Havering
LONDON BOROUGH

Daniel Douglas
Team Leader Transport Planning
Planning
London Borough of Havering
Mercury House
Mercury Gardens
Romford
RM1 3SL
t 01708 433220
e daniel.douglas@havering.gov.uk
text relay 18001 01708 433220
4th February 2021

London Borough of Havering (20025659) – Written Representation M25/J28 Improvement Scheme

M25 JUNCTION 28 SCHEME

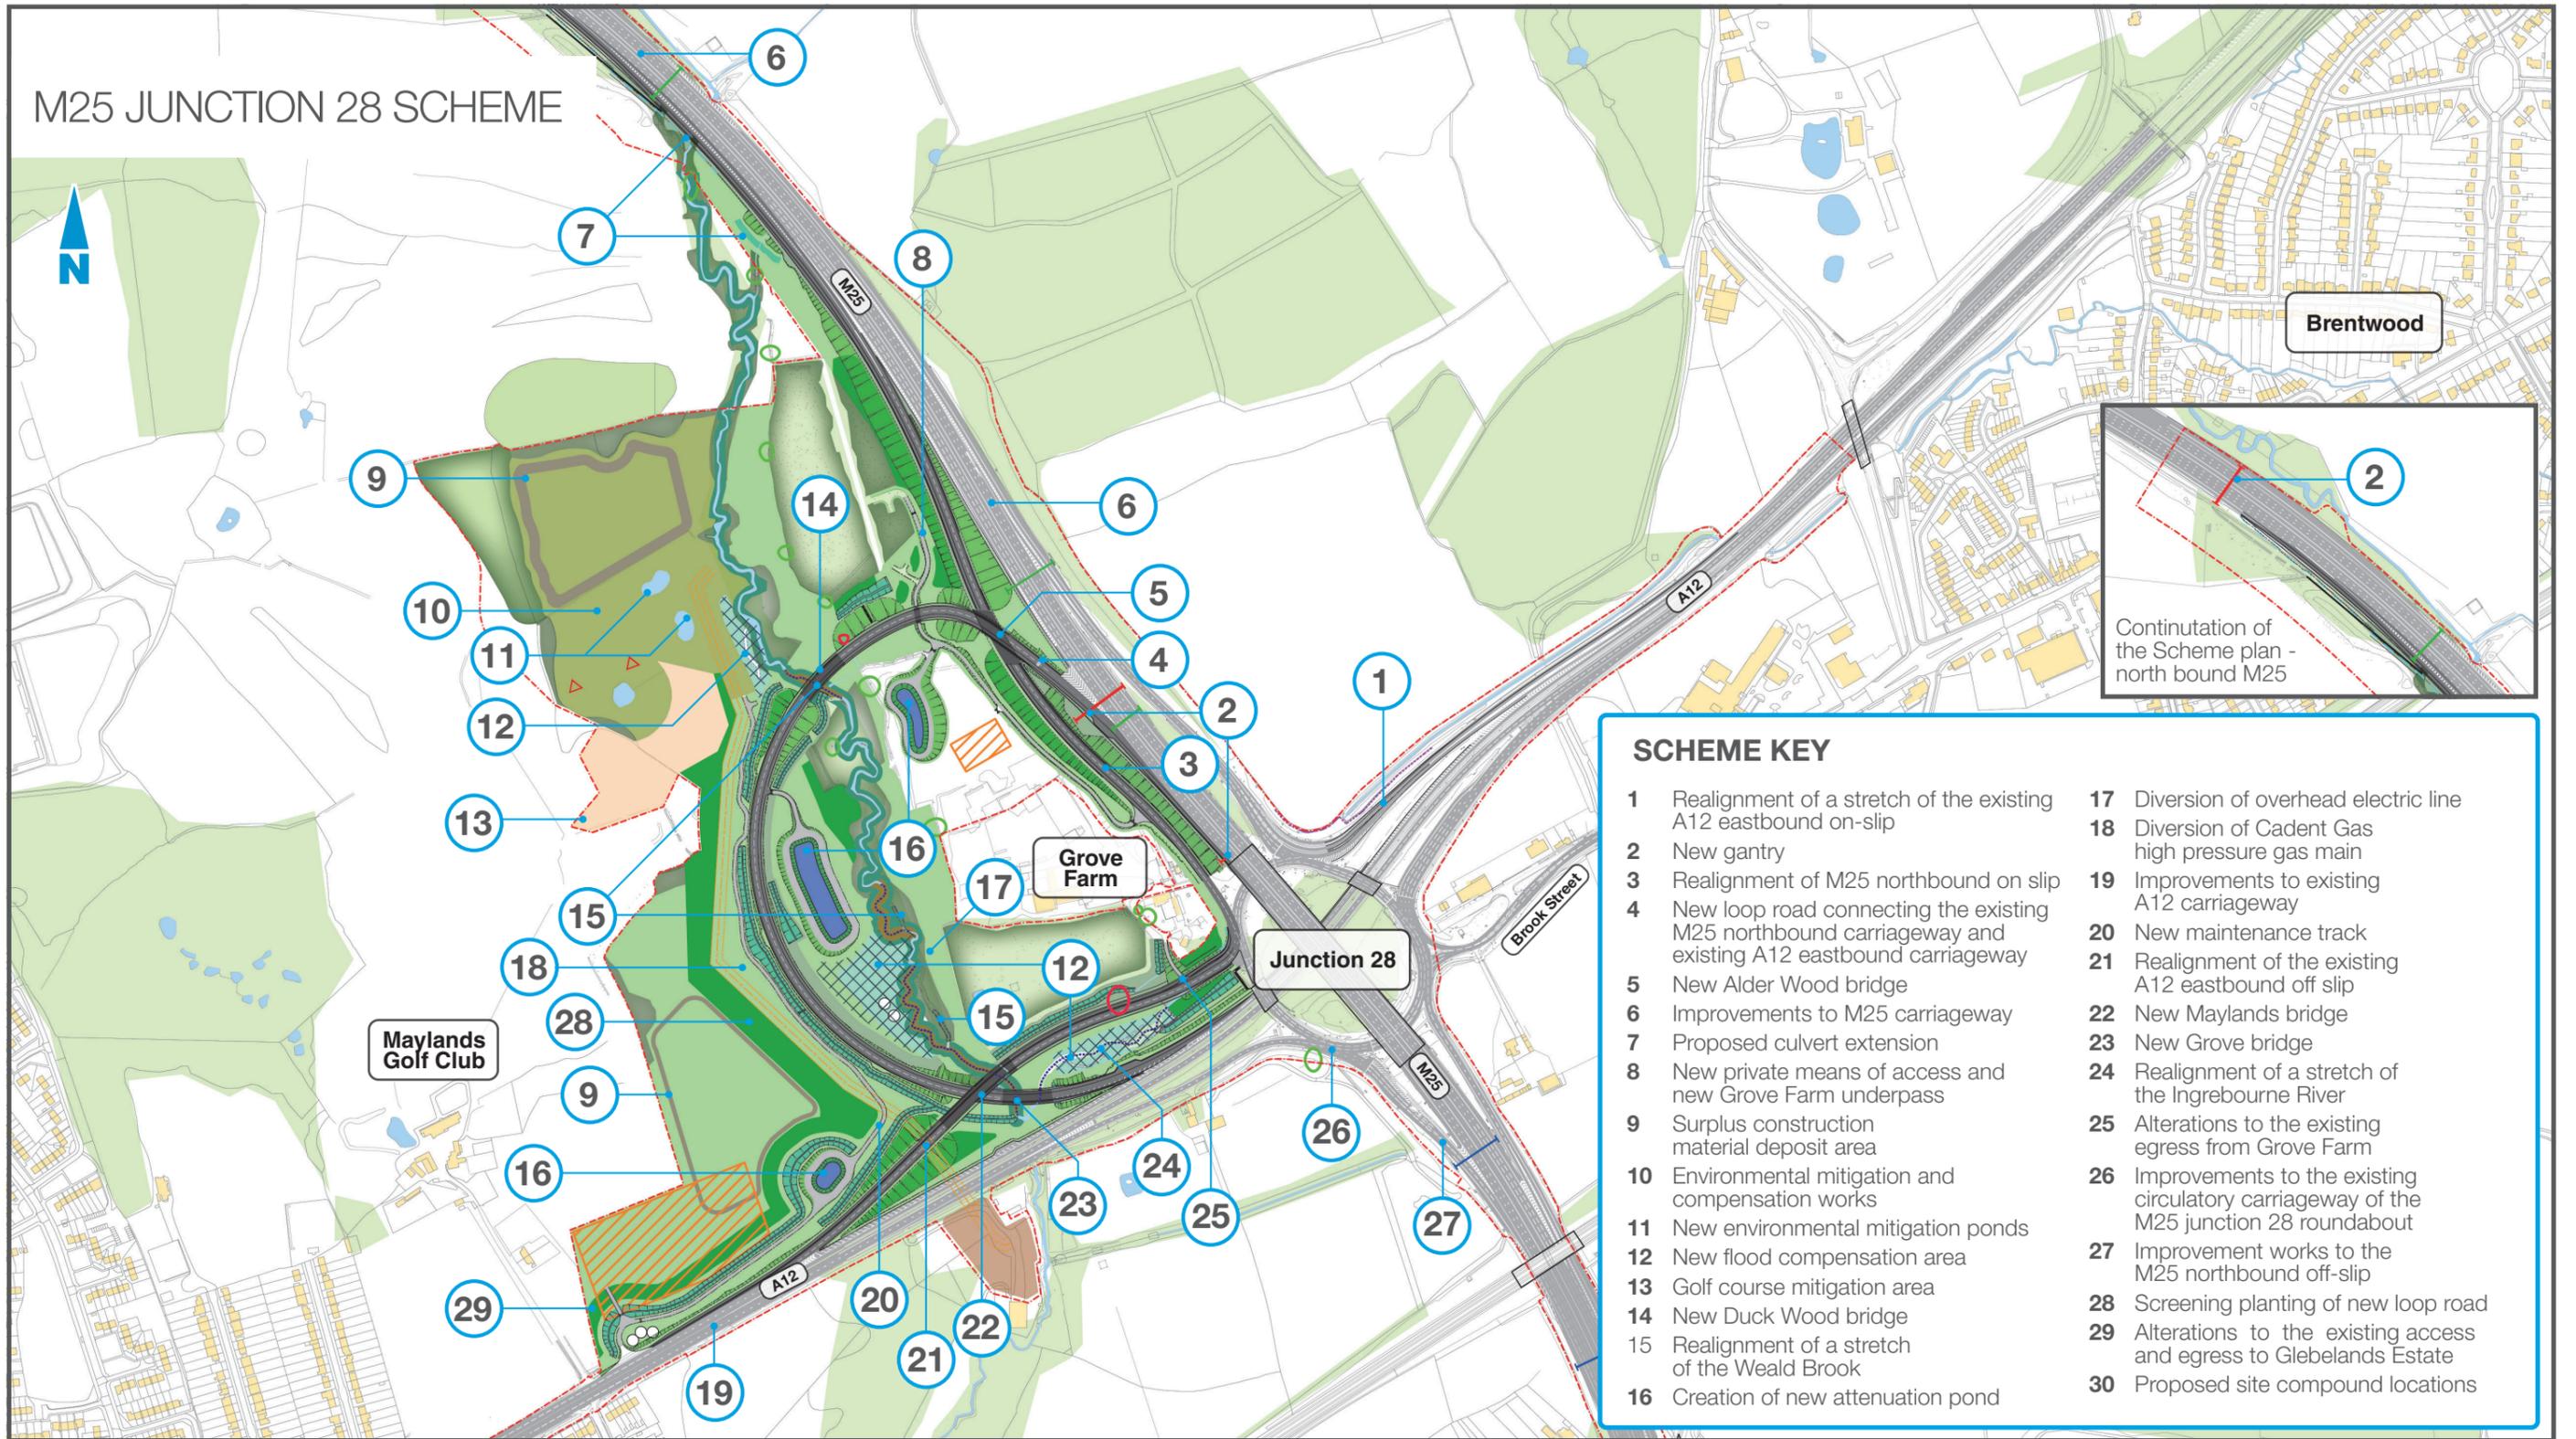
The Council has raised concerns that the scheme as currently proposed does not adequately support users of other modes of transport, particularly for those travelling by foot or by bike. A widened shared use path on the A12 eastbound off-slip is welcome,

however navigating the Brook Street roundabout by foot or by bike beyond this path is extremely challenging and dangerous at present and will remain so under the proposed scheme.

The Council has concerns over whether the relocation of the Cadent gas pipeline will result in an impact and loss of burial plots at the Gardens of Peace Cemetery. The Council is aware from the Relevant Representation (RR-024) and Procedural Deadline B submission (PDB-009) by Savills on behalf of the Trustees of the Cemetery site, that they have such concerns.

The Trustees have also indicated that burial plots would be impacted by the gas pipeline diversion and there are concerns that the easement strip will be sterilised from its intended use (burials). Further, the representations indicate that due to the service entrance having to be relocated, this will result in the soil storage area being moved which will further impact on burial plots.
